Project	Proposed residential scheme at Ledgard Bridge, Mirfield
Client	Binks Executive Homes Ltd, Cawthorne, Barnsley S75 4EJ
Dwg Title	(17001)10_Elevations
Scale	1:200 @ A1
Date	Jan 22

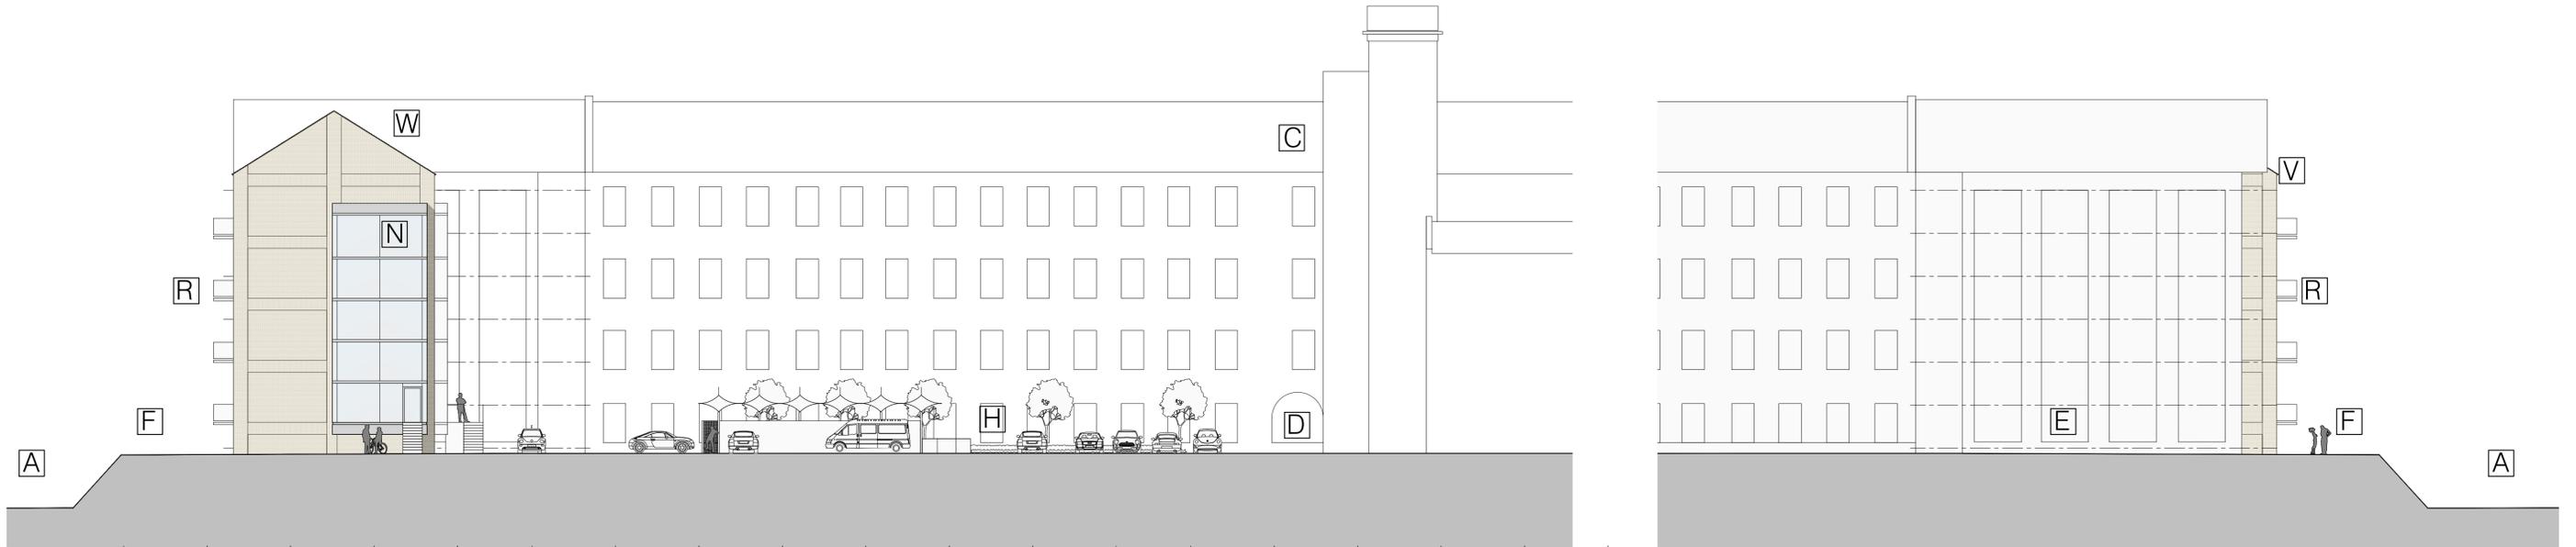
Another key concern is the impact on light, views, wellbeing and enjoyment of existing residents. The section of the building that houses south facing flats (those looking directly towards the river) will be highly impacted. We currently have views towards the river and beyond that Lower Hopton and Upper Hopton. This is a lovely, far reaching view which would be an entirely hidden if a six storey building was constructed. I understand affordable homes need to be build so would suggest a lower height building be considered for the wellbeing of existing residents.

Page 10 of the Planning Policy statement states that "lowering the height of the building would be judged to weaken the intended sense of enclosure..." – how would this be a negative? We do not wish to live in an enclosed compound. And "it is not considered that the proposed development would have any significant detrimental impact on light or would create an oppressive outlook for existing residents." I wholeheartedly disagree with this statement and would invite the developers to come take a look from my flat and imagine a building of equal height to the existing mill placed directly in front of my window and tell me but that wouldn't have a detrimental impact.

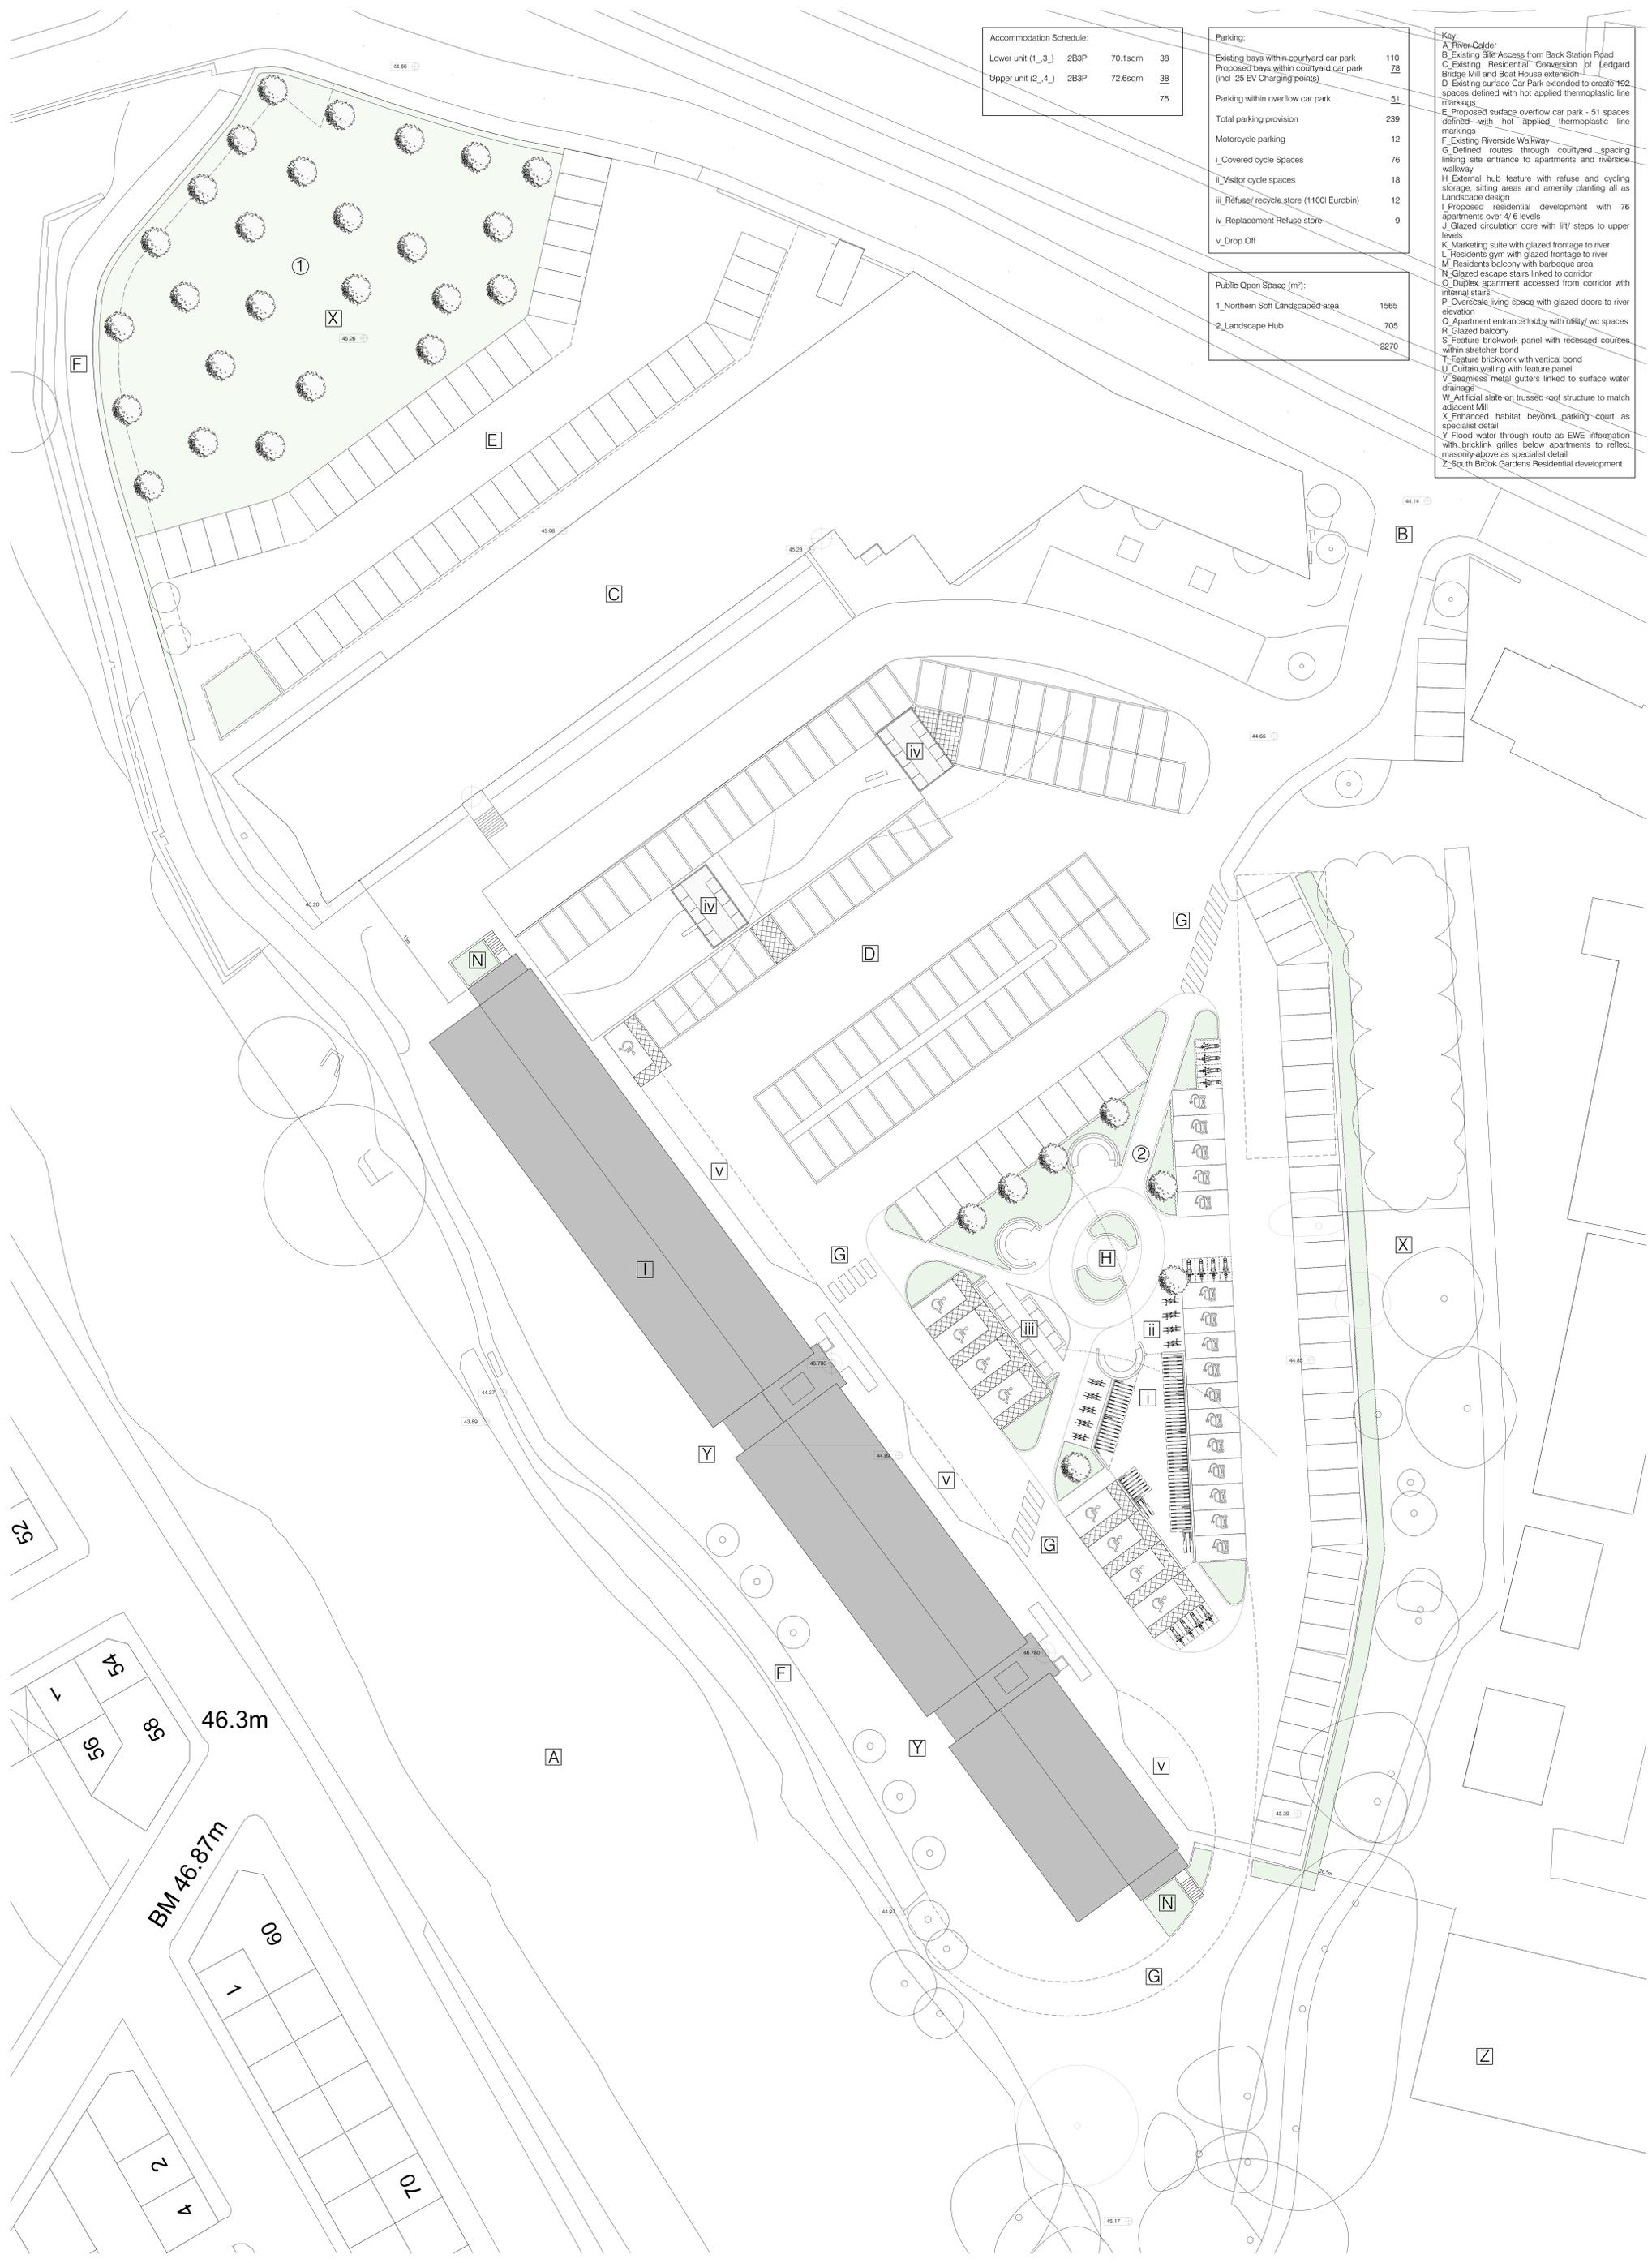
On parking and traffic: I can see parking spaces have been allocated for the proposed development however this needs to ensure there is adequate visitor parking as well as residential car parking because there is very limited capacity on the surrounding roads for visitor parking. Back Station Road is full every day as it is essentially used as residential and a park and ride for Mirfield train station. There is no overflow capacity for extra cars. It's great to encourage more people to use public transport and active travel modes but realistically this development will create additional car traffic which needs to be mitigated for.
